20th November 2015

**Re: Planning Application Ref:6/2015/2223/HOUSE by Mrs K. Anklesaria
At 45 Northaw Road East, Cuffley, Potters Bar, Herts EN6 4LU.**

Rev	Details	Date
	MD DESIGNS 9 JEPPI CLOSE, GOFFS OAK HERTS, EN7 6UT 01992 630 520	
CLIENT	Mr & Mrs Anklesaria	
LOCATION	45 Northaw Road East Cuffley EN6 4LU	
PROPOSAL	block plan	
Date:	October 2015	
Scale:	A3@1:500	
Dwg:	nor/plan/15	3

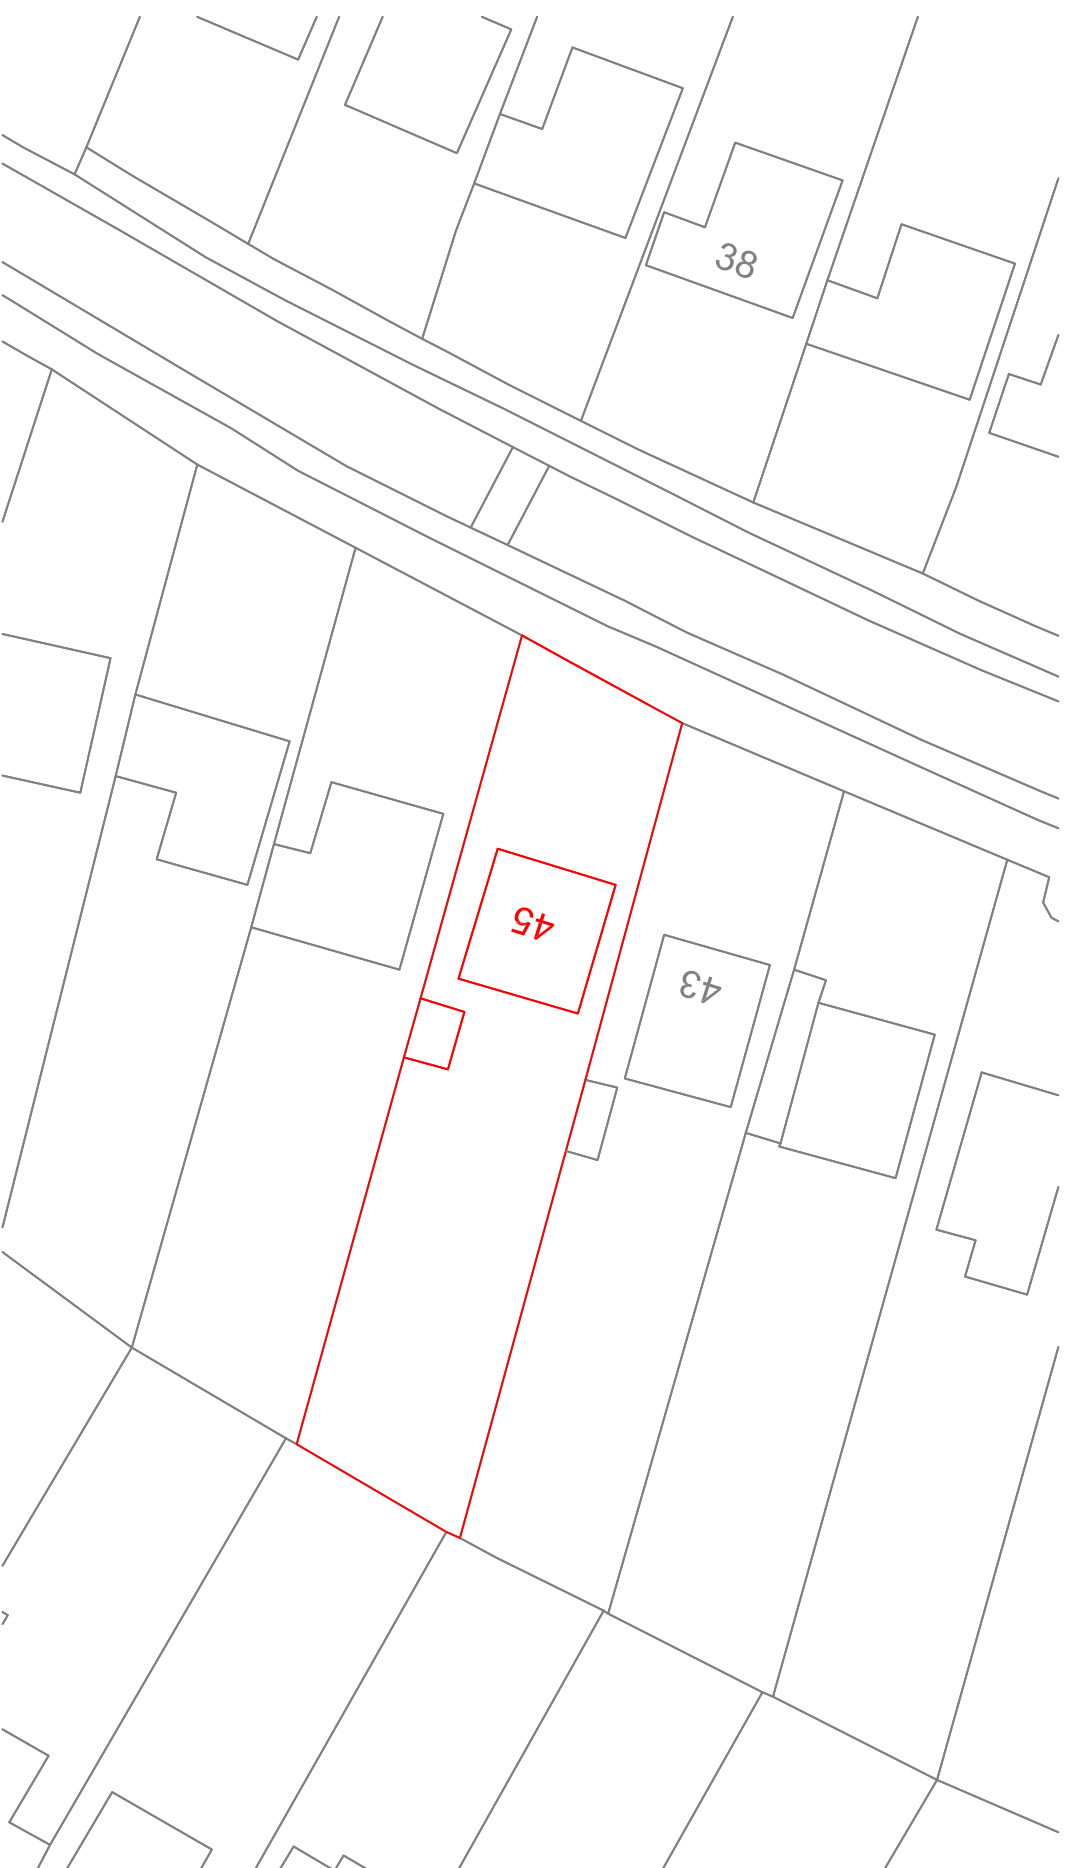
The Block Plan of the properties filed with you does not reflect the true position of our property as available from the Land Registry.

| Rev      | Details                  | Date |
|----------|--------------------------|------|
| Dwg:     | nov/plan/15              | 1    |

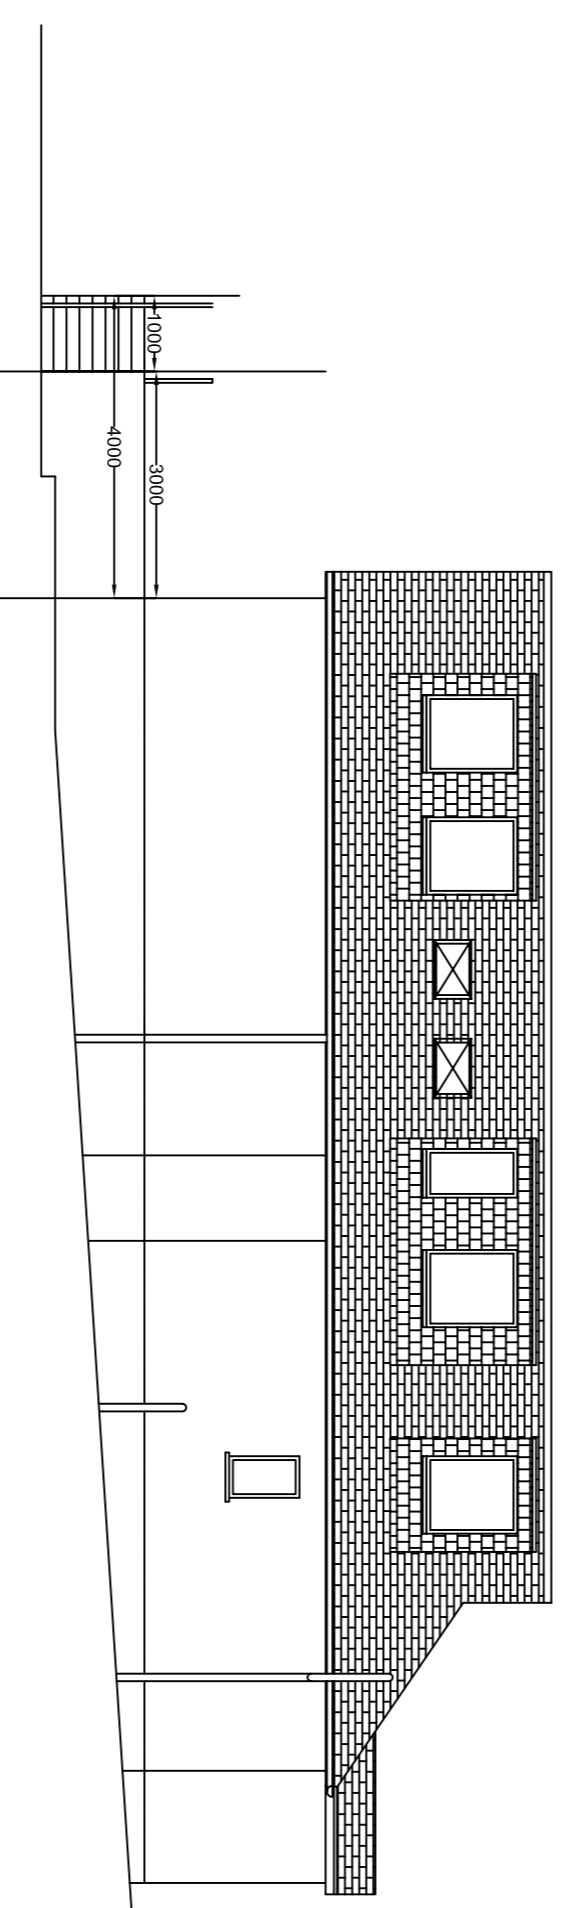
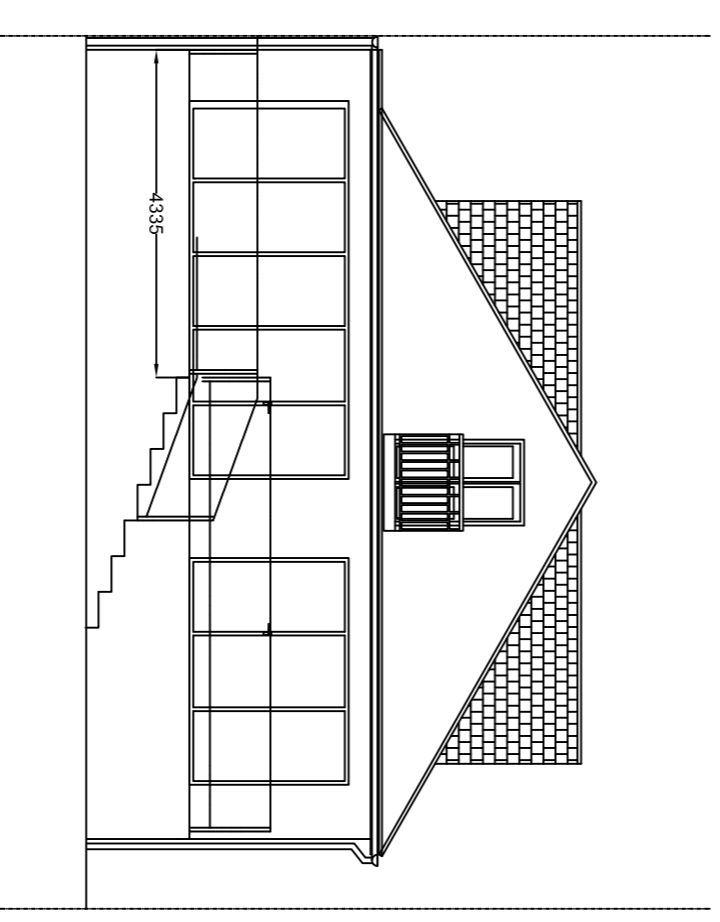
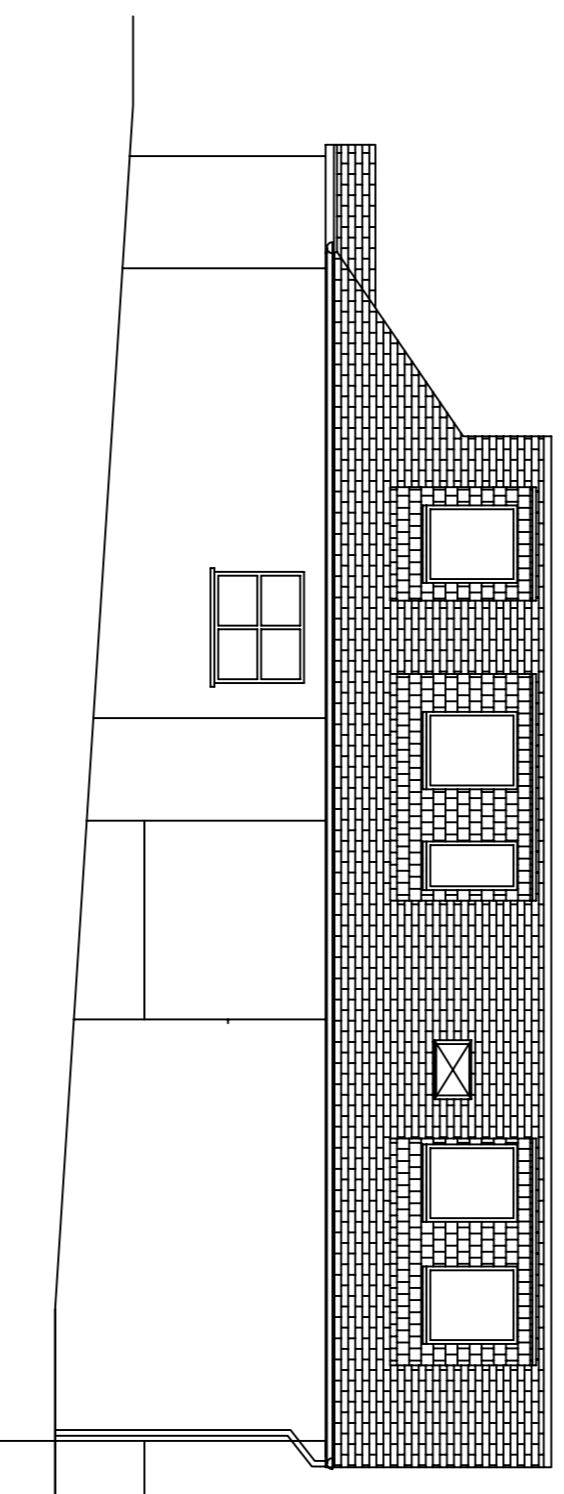
The plans do not state the size of the three Dormers with measurements, as they appear to be Oversized and Overbearing without council restriction.

We suggest that the Dormers facing our property should be Scaled back and fitted with fixed Obscure Glass with high-line shutters. This is because we will be directly overlooked into our Bedroom, Kitchen and Deck with a loss of privacy. We would draw your attention that you have approved, in the area, dormers without windows but with highline shutters, where they overlooked the neighbouring property.

Similarly, we suggest that the proposed Juliet Balcony should be a rail guard with a window. The application for opening doors should not be approved as it will overlook the our garden and deck. Therefore, the Juliet balcony should be fitted with inward opening windows.

The Level of the property at No. 45 is lower which would adversely affect our Existing Right to Privacy and to Light. Therefore we suggest, the proposed Rear Extension at No. 45 ought to be a single storey and should be restricted to three meters under the present permitted development. This restriction should apply to include both the rear dwelling and the proposed rear loft extension.
